2003 INTERNATIONAL BUILDING CODE® PLAN REVIEW RECORD

BUILDING LOCATION: 132 Riverside St.
 (Street address)

BUILDING DESCRIPTION: Burger King

CORRECTION LIST

A2 TRUSS PROFILES
1/4" = 1'-0"

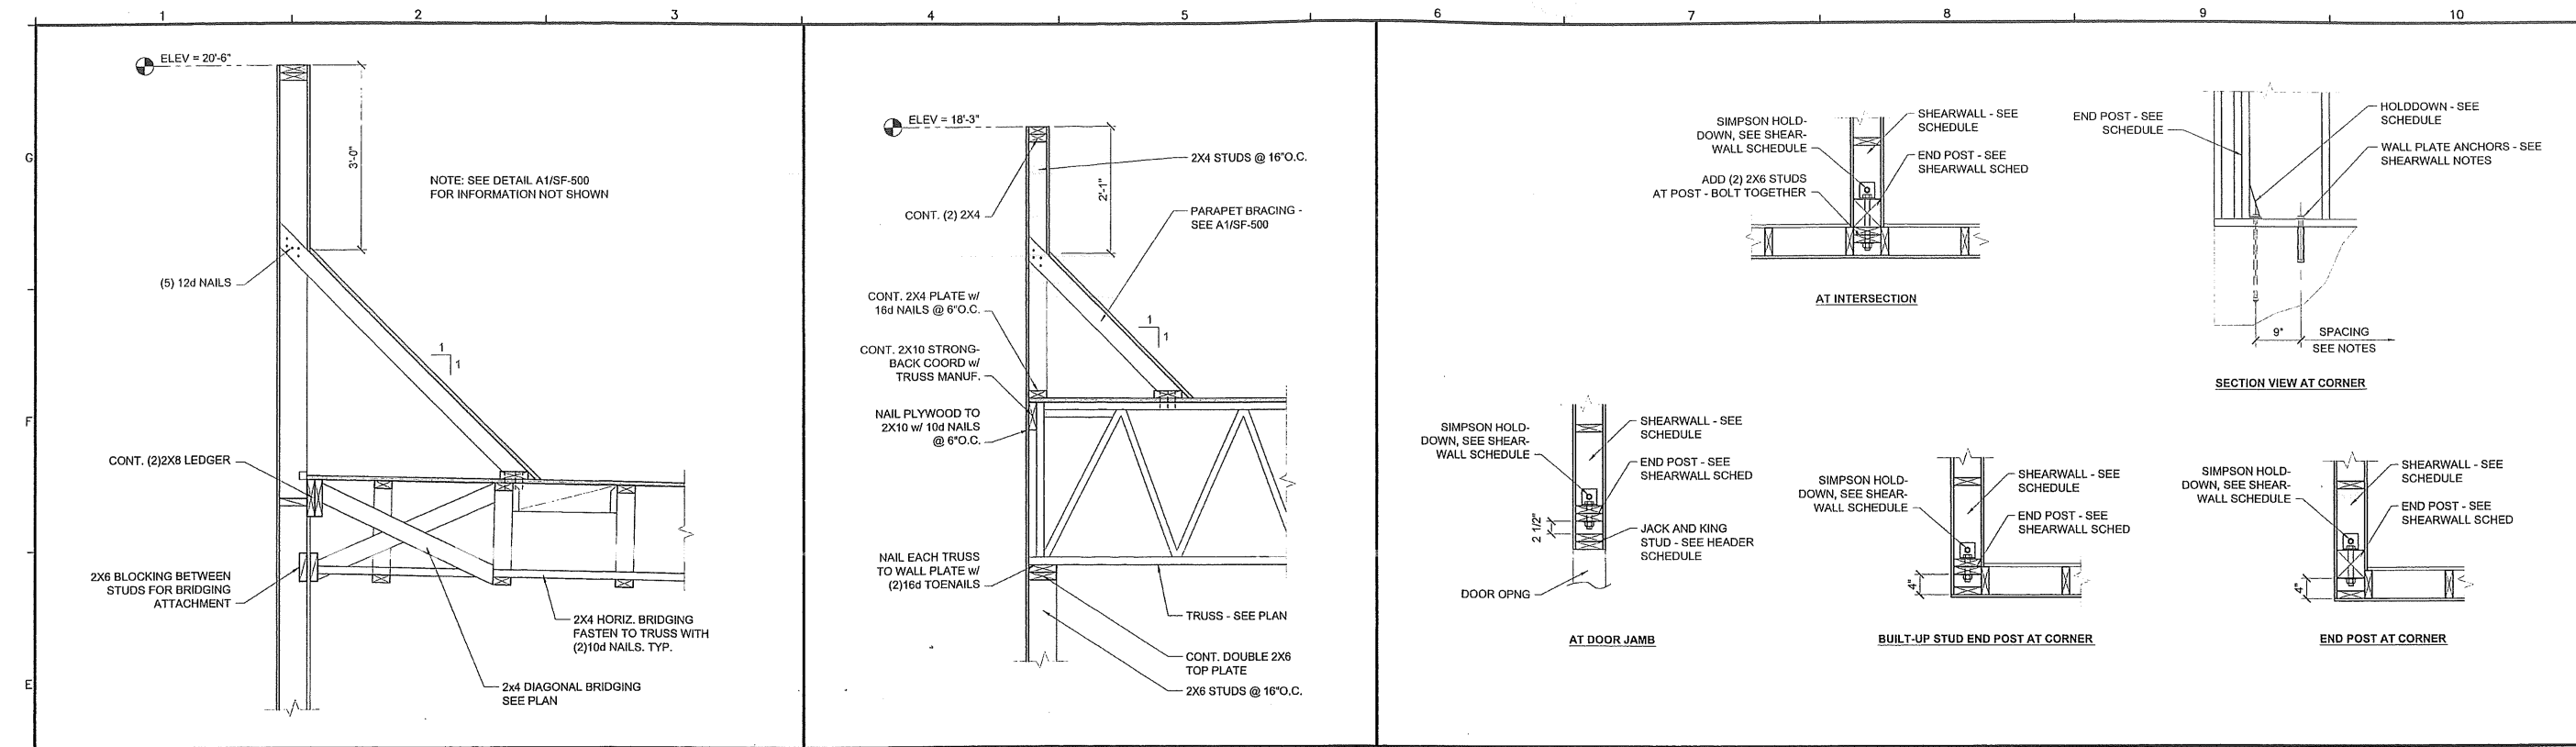
No.	DESCRIPTION	Code Section
1	Letter from Design Professional - Plans meet 2003 IBC Plans use 2006 IBC.	
2	Code Summary?	
3	Spec Book copy requested.	
4	Com-CK?	} Mark
5	Statement of Spec. Susp.?	
6	Specs on Trusses - Condition of permit.	
7	Elect, Plumbing HVAC, Signage sep. permits req, Cond.	
8		
9	Food Service Lic. - Cond.	
10	ST Fire Marshall Permit - Issued/ADA	
11
